Revision #5 narrative (Kitchen redesign)

DATE: May 31, 2023  
PROJECT ARCHITECT: ELEVEN18 ARCHITECTURE, PL  
CONTACT NAME AND NUMBER: Matt Conte, 407-745-5300

**PROJECT NAME:** The Springs of Ballentine  
**PERMIT NUMBER:** N/A  
**PROJECT NUMBER:**  
**FID NUMBER:**

PLEASE NOTE THE FOLLOWING REVISIONS TO THE PROPOSED SET OF DRAWINGS HAVE BEEN COMPLETED  
IN RESPONSE TO REVISED FOOD SERVICE DRAWINGS.

M102
PARTIAL HVAC PLAN

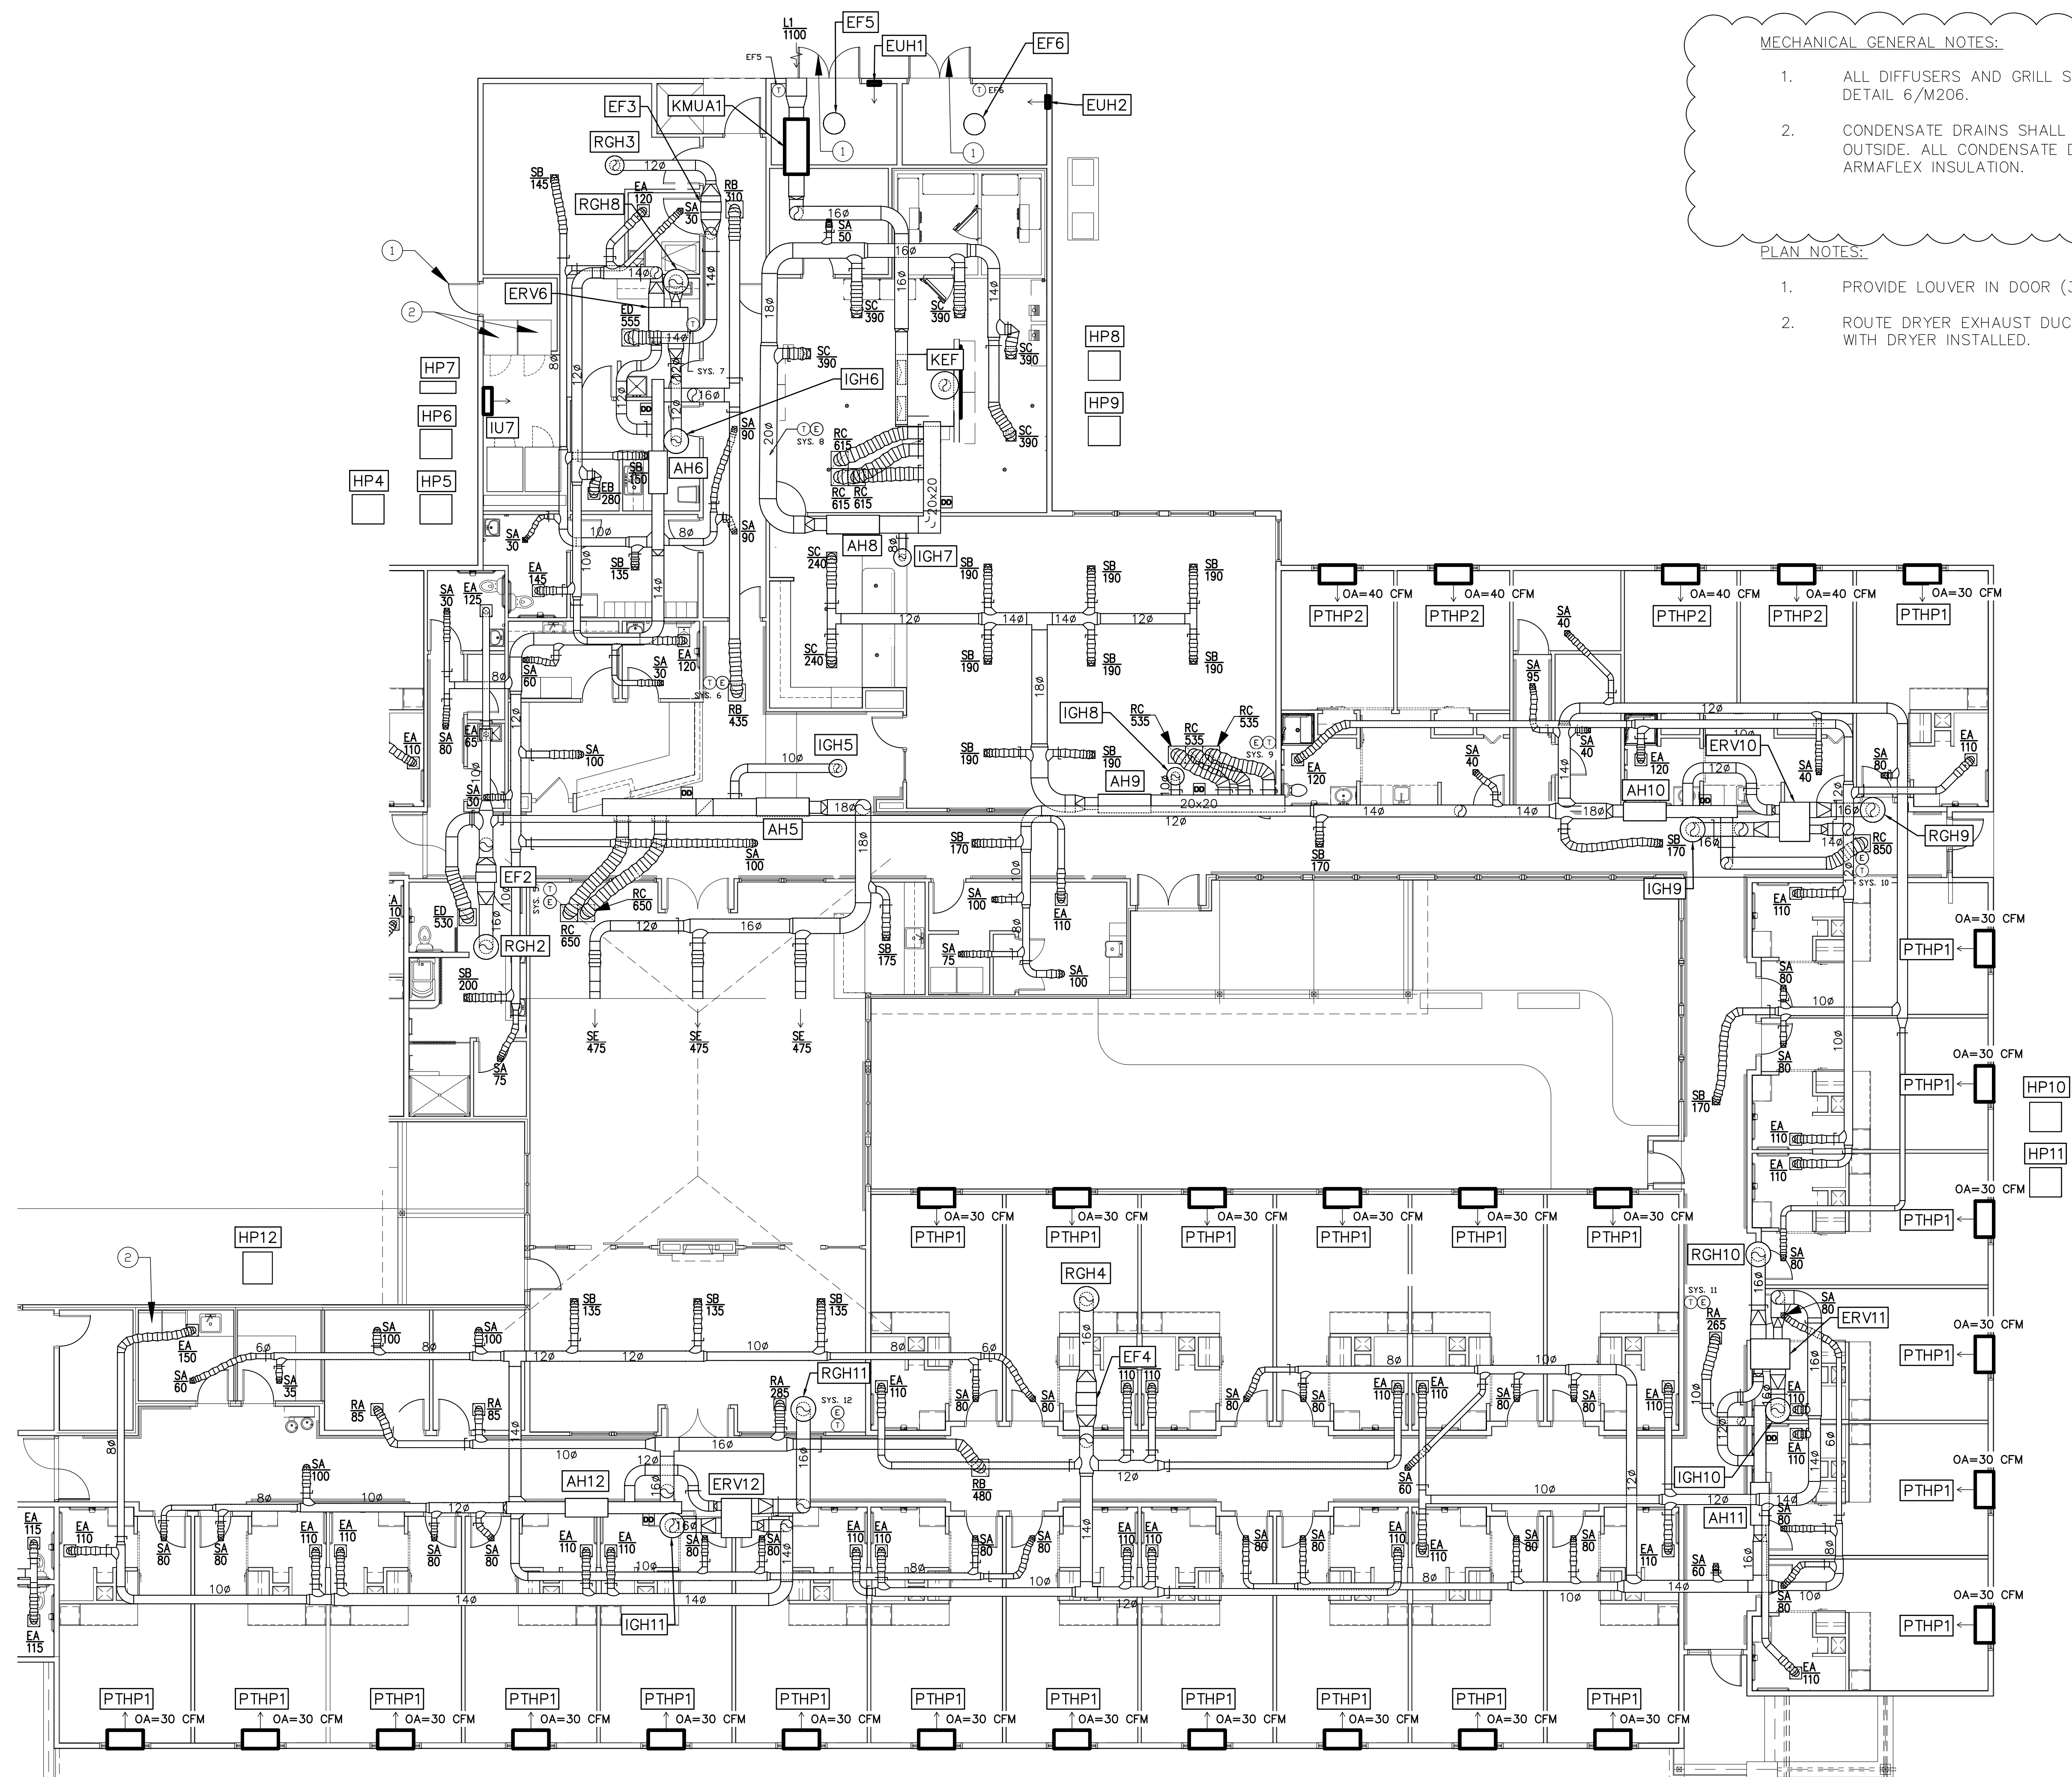
M102

Revised kitchen HVAC plan
